FAREHAM

BOROUGH COUNCIL

**Fareham Borough Council - Relevant Representation
Hampshire Water Transfer and Water Recycling Plant Development Consent Order
Application by Southern Water Services Limited**

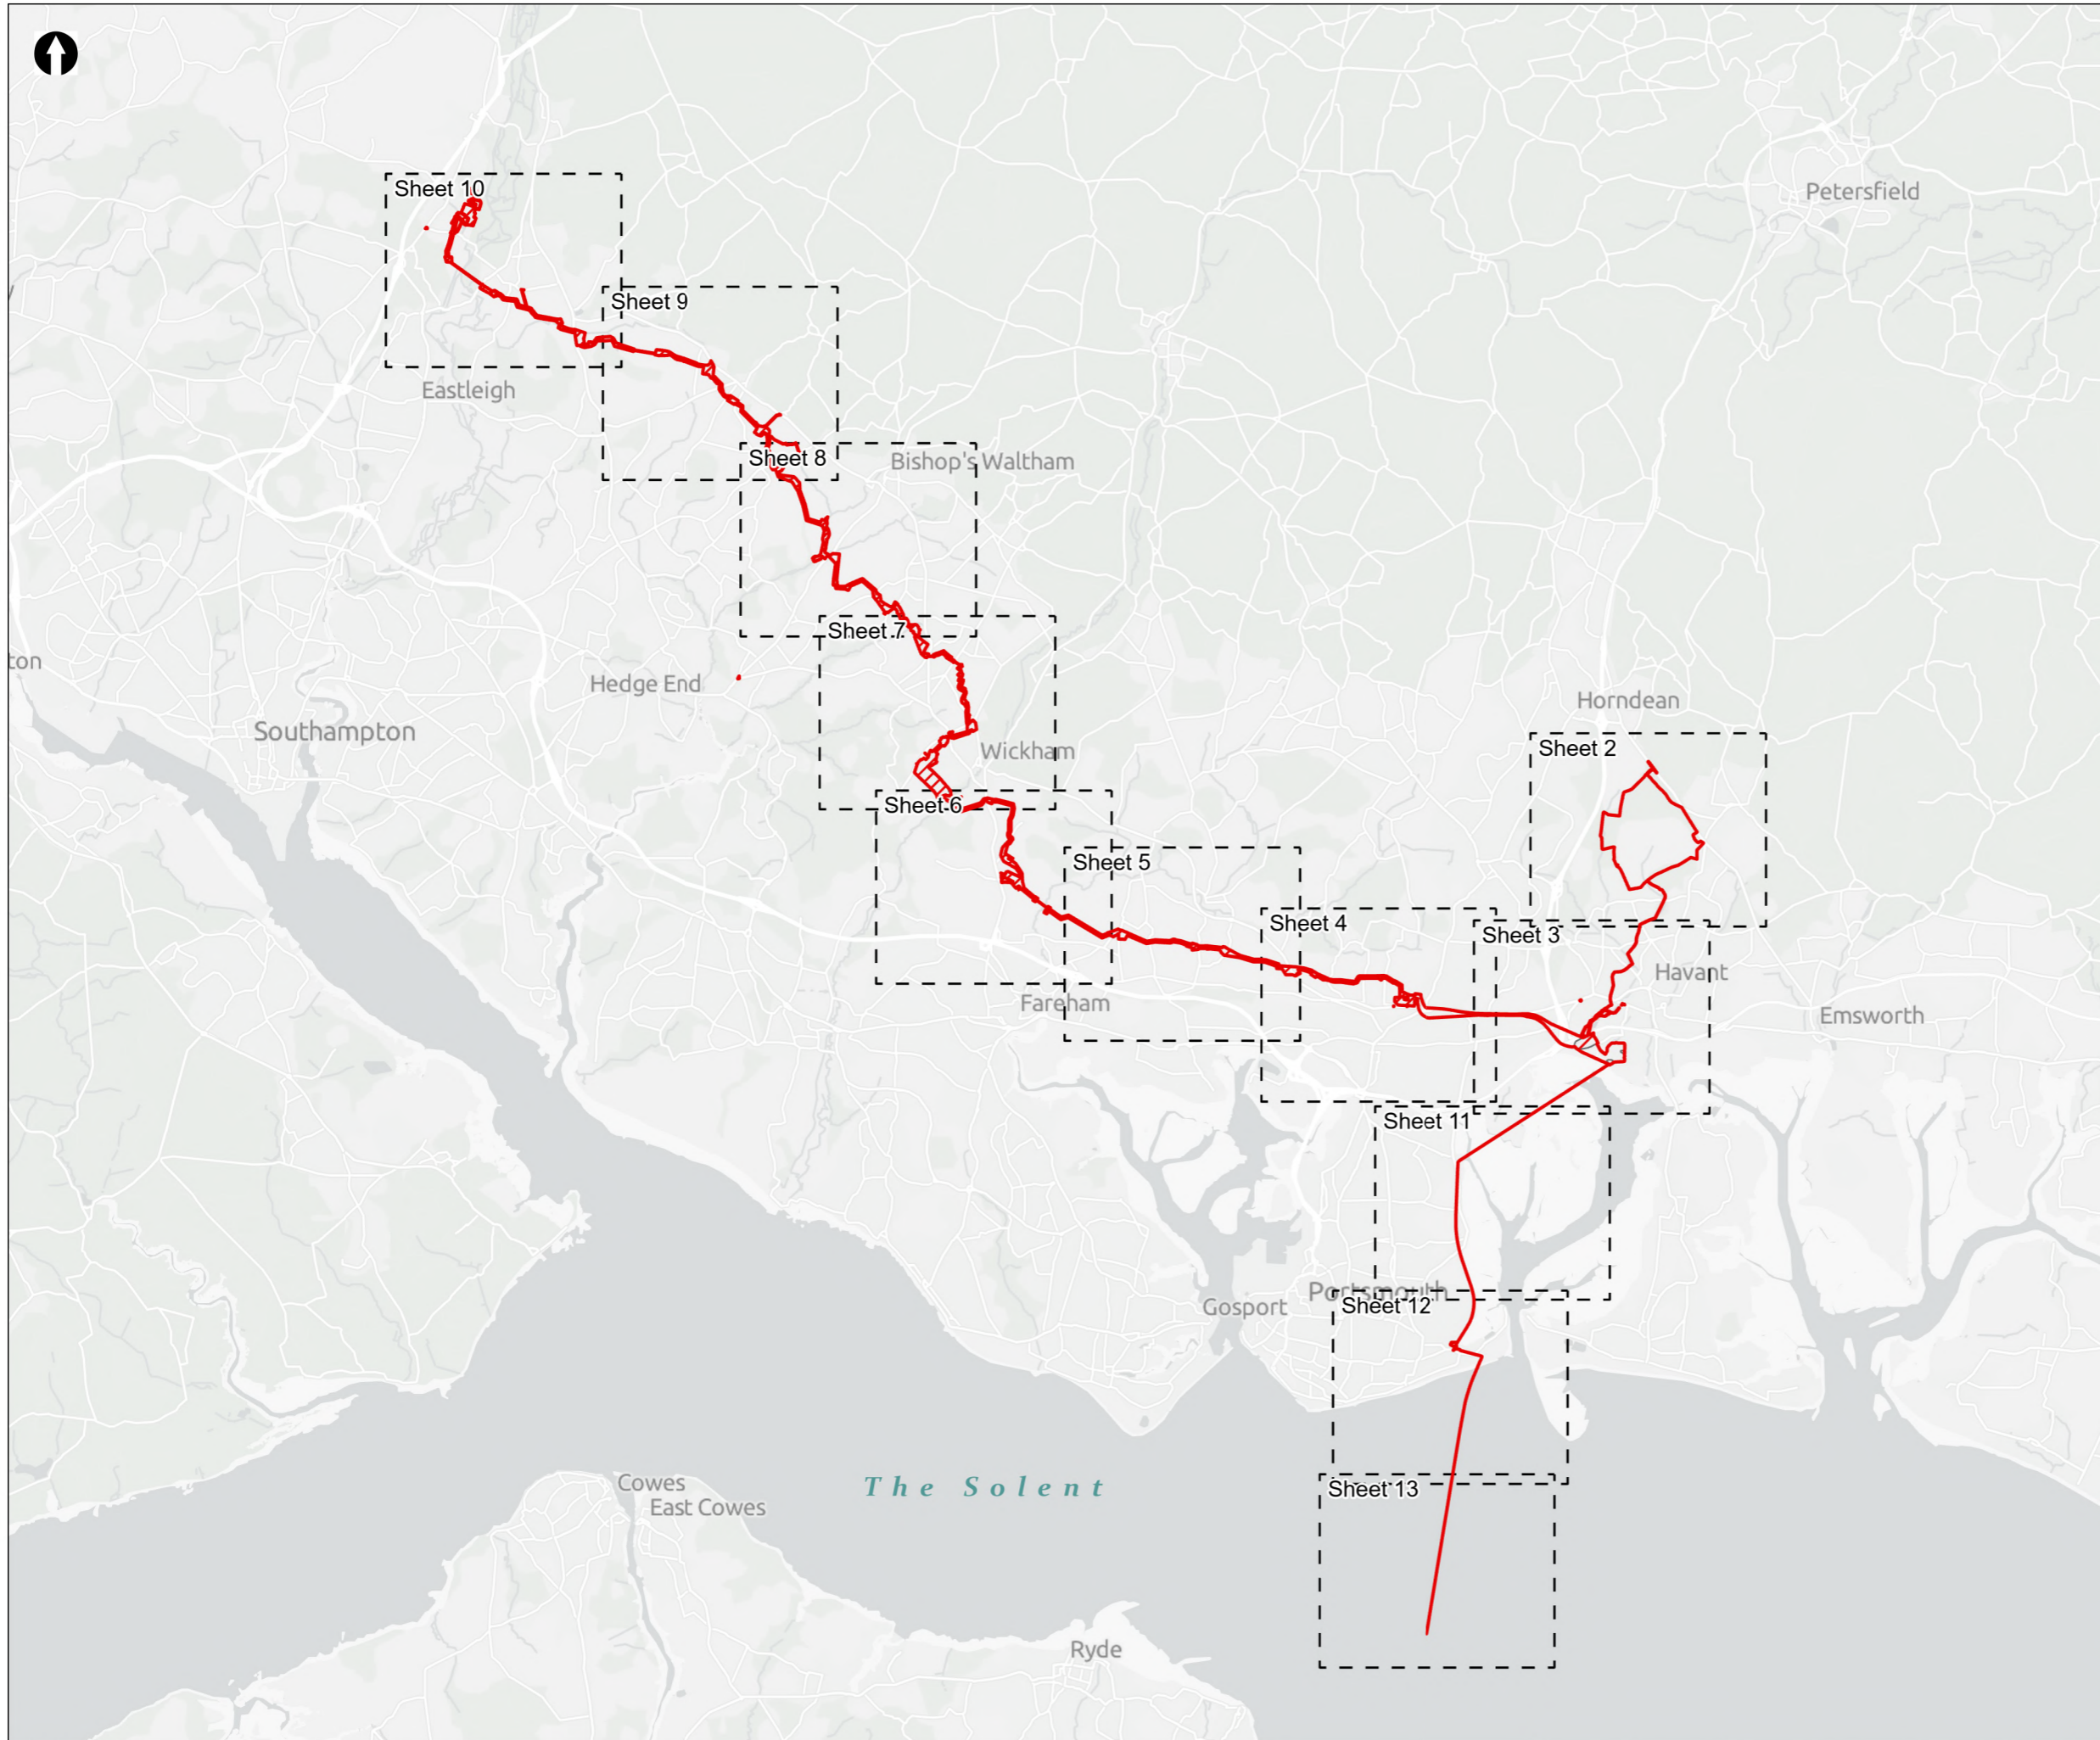
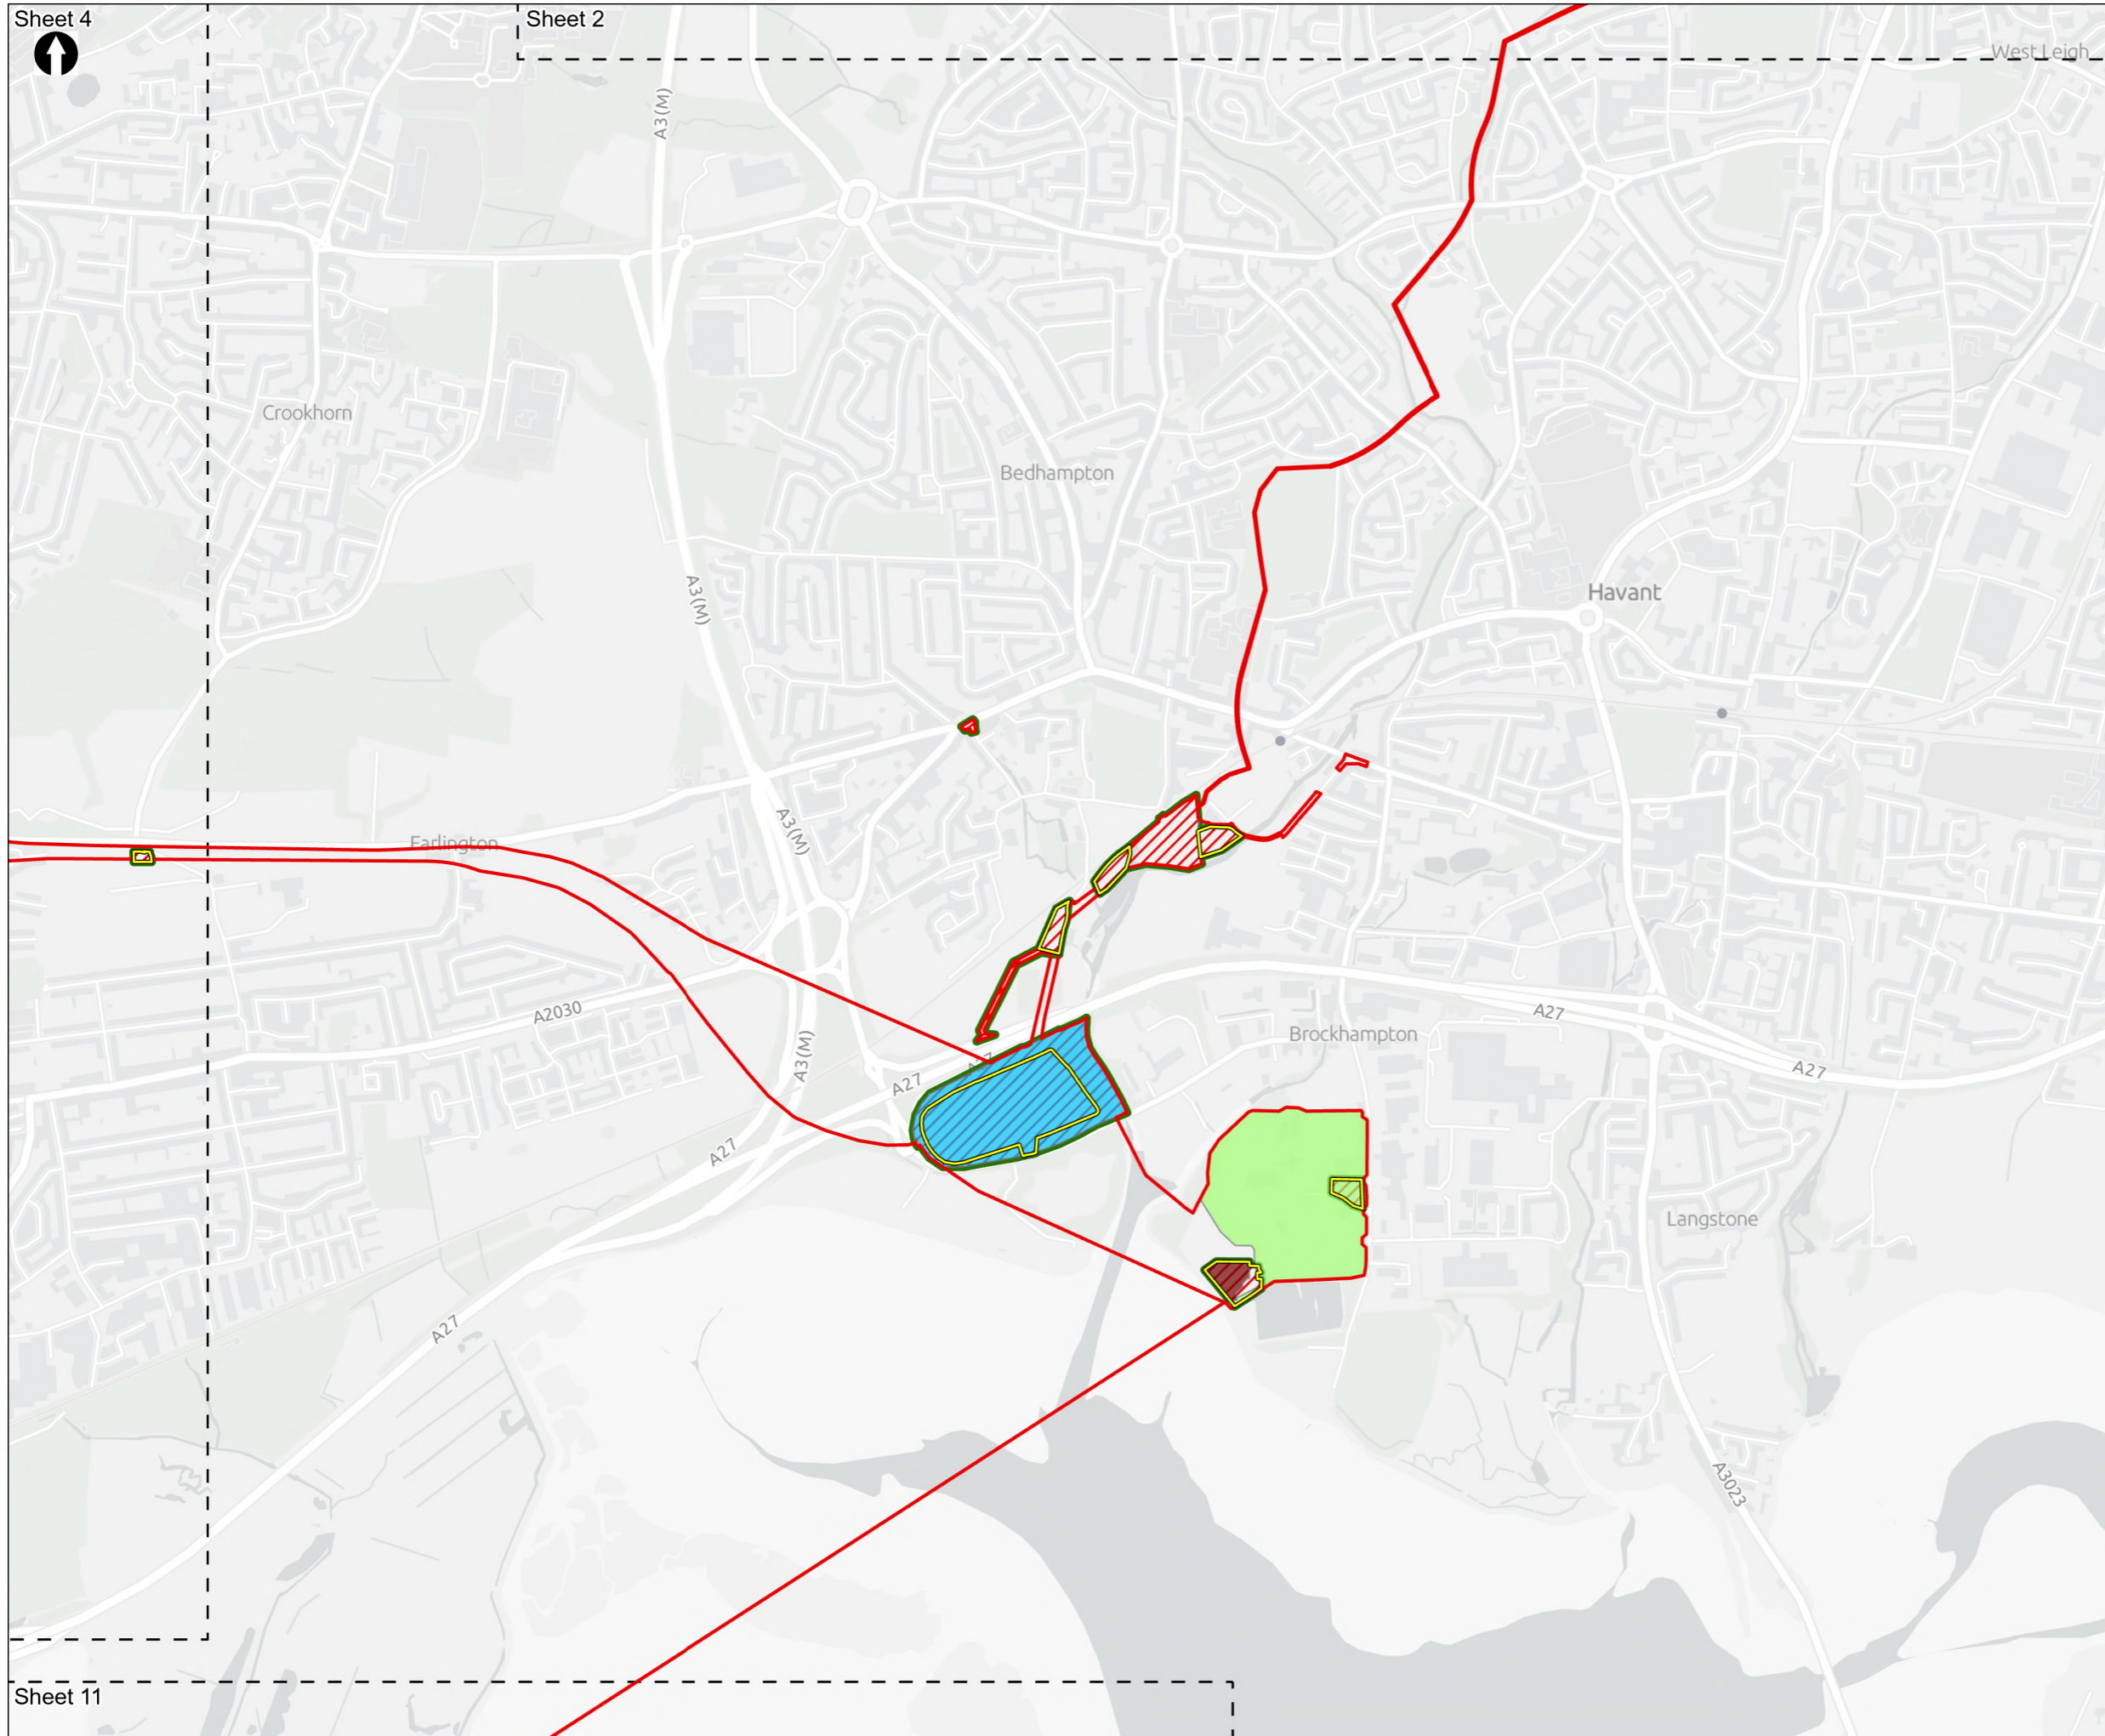
Whilst there will be a 15m buffer between Carpenters Copse Ancient Woodland/SINC and the works, there will be medium-term severance of the woodland/hedgerow network connected to this Ancient Woodland in areas shown below in yellow. Therefore, FBC is not clear why the modelling and survey work (statics and nighttime bat walkovers) did not cover this area, as a sampling location and key connective location, for the presence of bats, particularly Annex II bat *Barbastelle*. Instead, a static was placed at the crossing with the River Wallington, where the impact is limited due to the trenchless nature of the crossing. Given the large number of Ancient Woodlands located to the east, west and north of Carpenters Copse, it is not considered that sufficient survey work has been carried out to understand the baseline and enable impact assessment/proportionate mitigation in the areas to be affected as a result of severance of commuting routes for bat populations.
